AW-344-14-HH – 68 The Drive – extension and swimming pool – 10-2-2015

OBJECTION – AW/344/14/HH – 68 The Drive – extension and swimming pool
within the
Craigweil House Conservation Area and Area of Special Character

Job Title
FIRST FLOOR PROPOSED

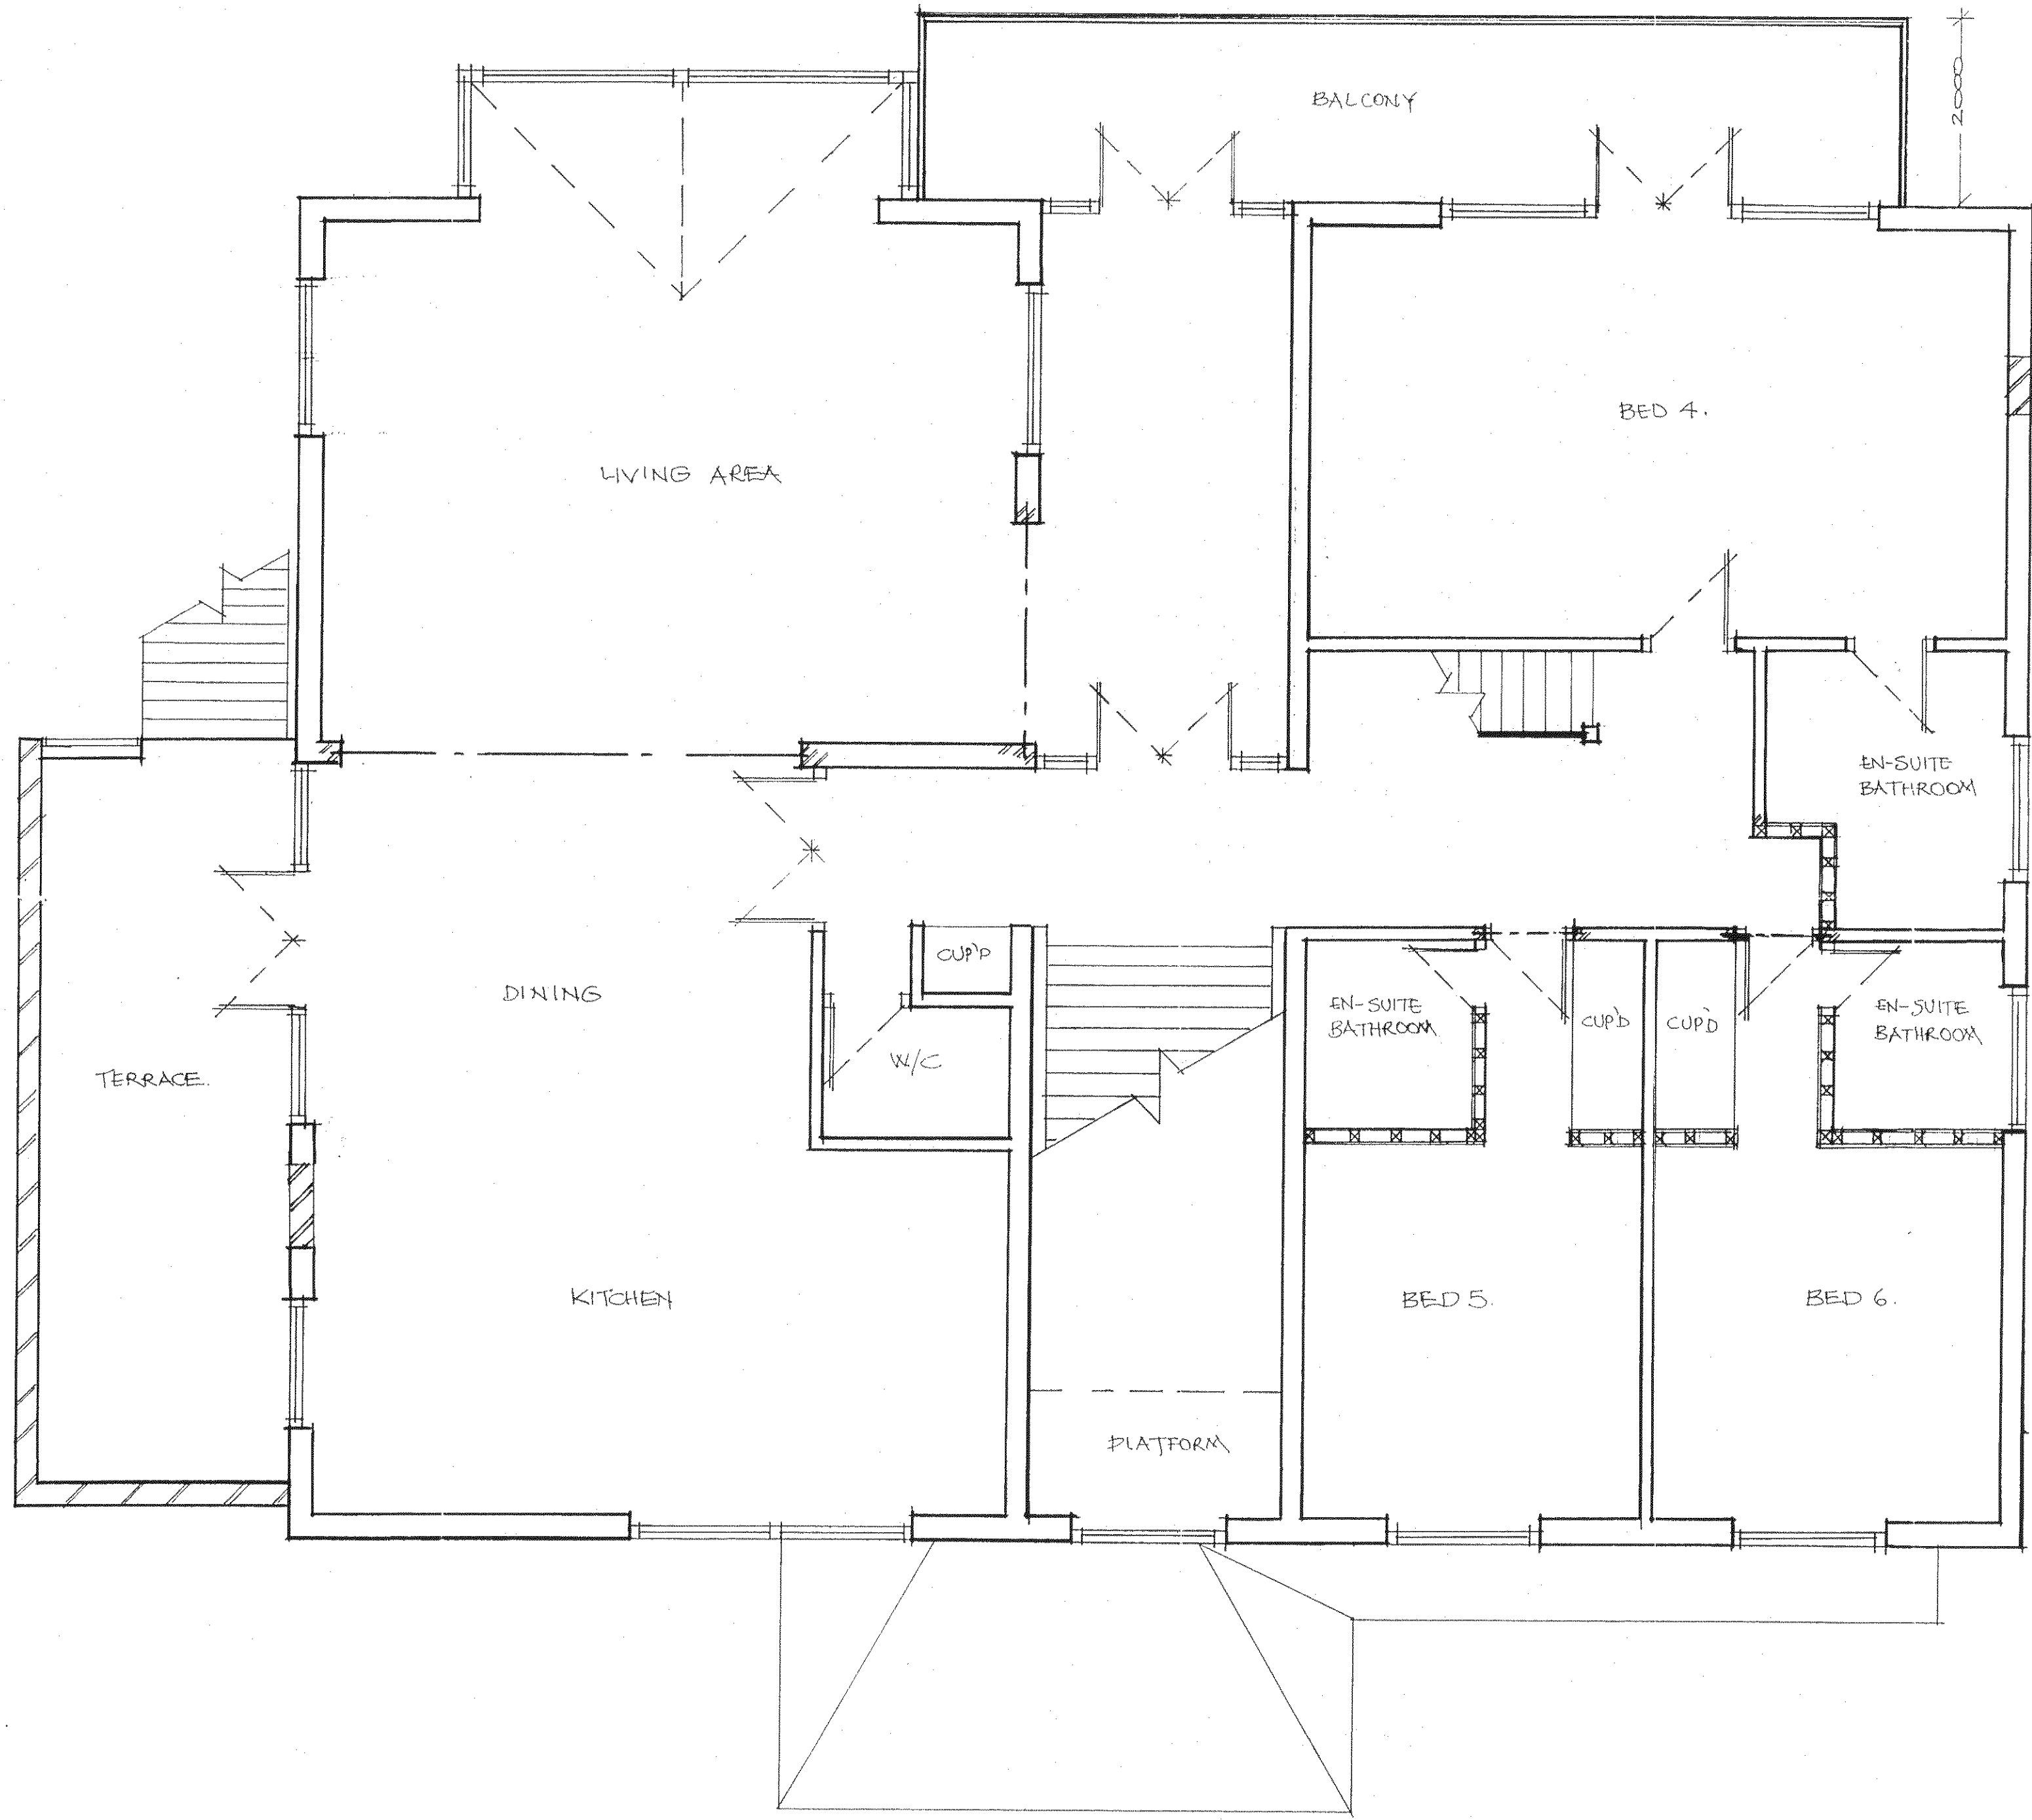
2. Flying in the face of GEN7, again, we say that this development will have an unacceptable adverse impact on adjoining property occupiers on each side. To the east, the proposed ‘terrace’ will, on its eastern edge, align with the boundary with No. 70. It will then have a stainless steel railing with clear glass surround. That terrace will, effectively, sit on top of all who may use the garden of No. 70 and this displays the fact that the applicant has not respected part (v) by taking into account this totally unacceptable adverse impact that may arise. The very concept is unreasonable and needless and selfish for there is ample existing balcony to the rear and south side of this very substantial house. Subsequently, the proposals cannot be seen as making a positive contribution to the quality of the environment as is required by GEN7.
